Please ask for: Mrs D Johnson
Email: daun.johnson@arun.gov.uk
Telephone: 01903 737762
Our Ref: FP/257/21/PL
Your Ref:
Date: 3rd December 2021

Application for Planning Permission

Development: Single story rear extension with alternation to provide an additional surgery room, Staff room and office space and better accessibility. This site is in CIL Zone 4 (Zero Rated) as other development.
Location: Newholme Dental Surgery 61 Middleton Road Felpham PO22 6BW

Block plan
1 : 500

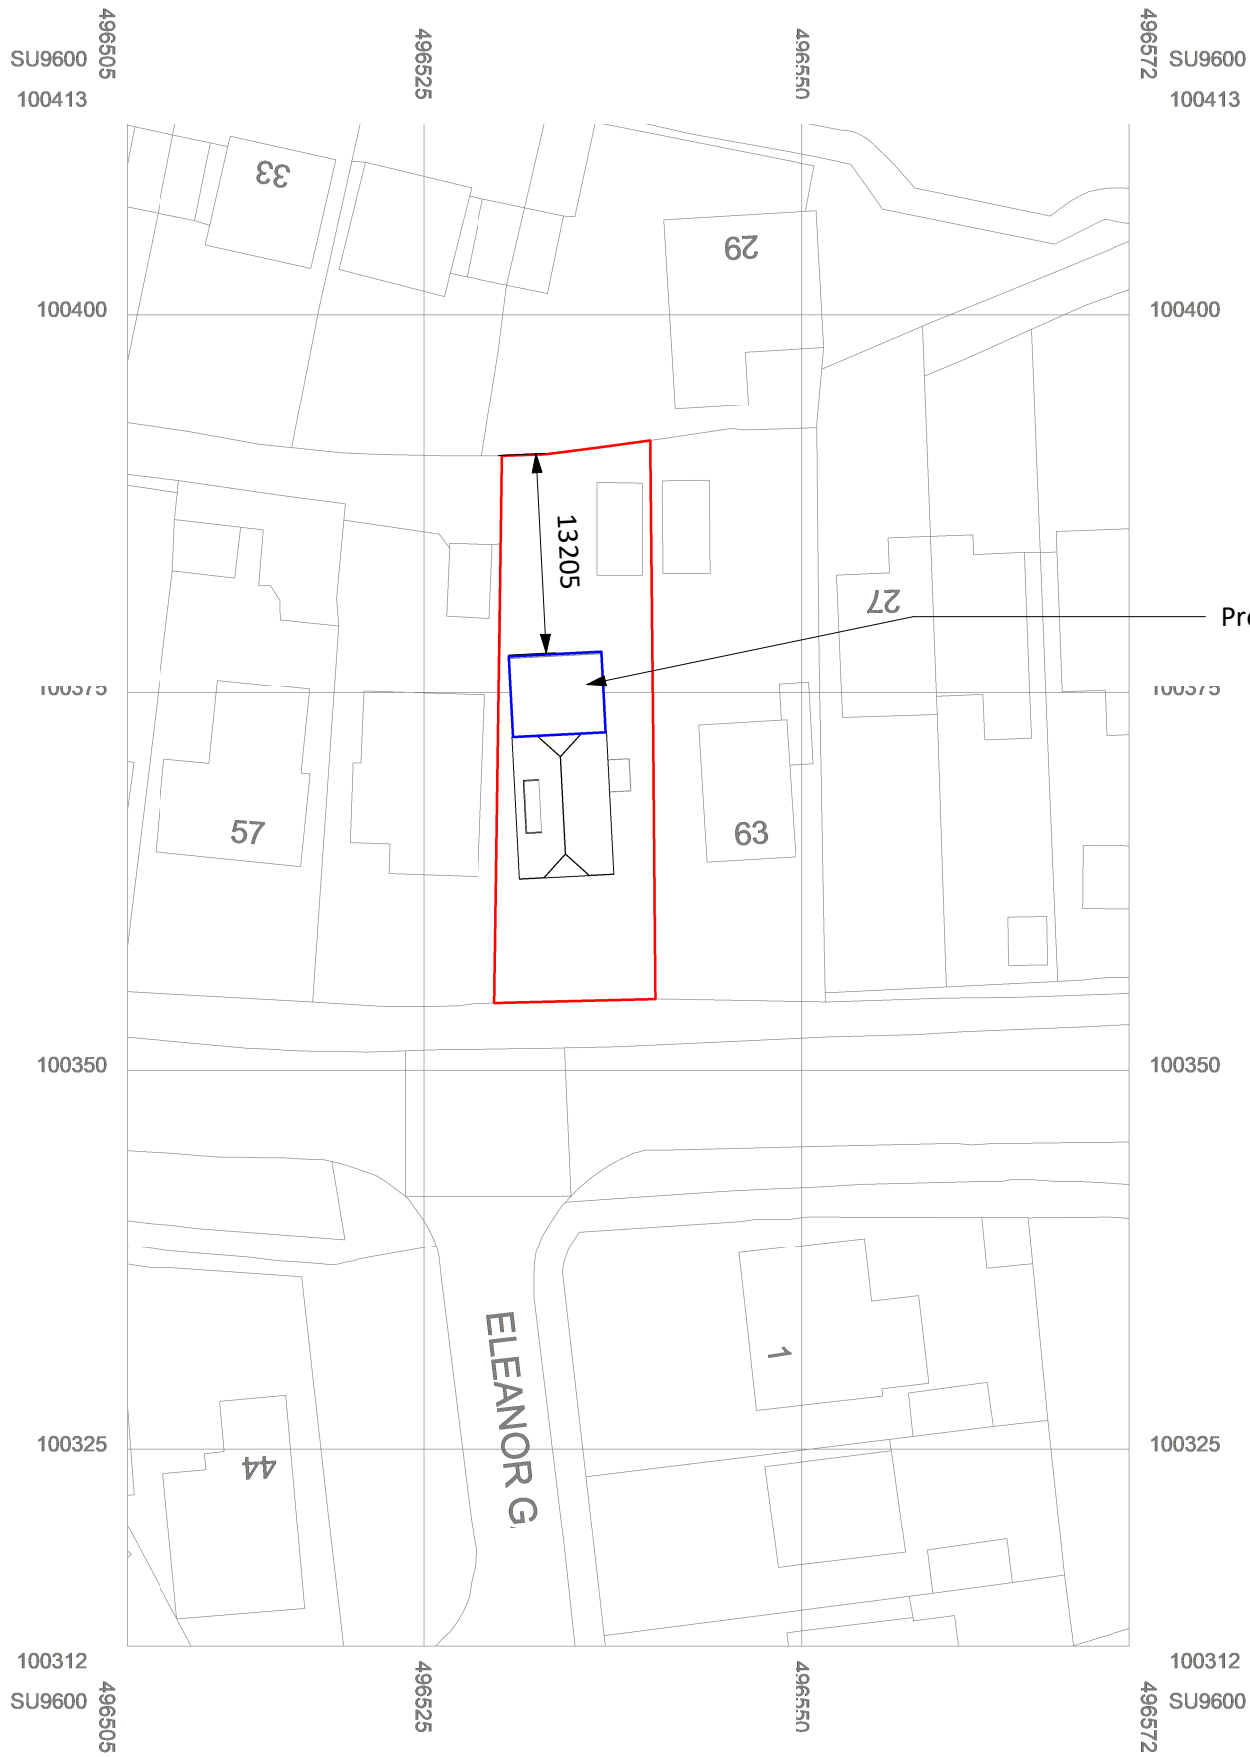
Block Plan

Please provide a north point, clearly highlight the proposed works and provide a measurement from the proposal to the rear boundary.

Location Plan

Please submit 1 electronic or 3 paper copies of a location plan at a scale of 1:1250 or 1:2500 for rural areas. Further details of what must be included on the plan can be found in the Validation Requirements List.
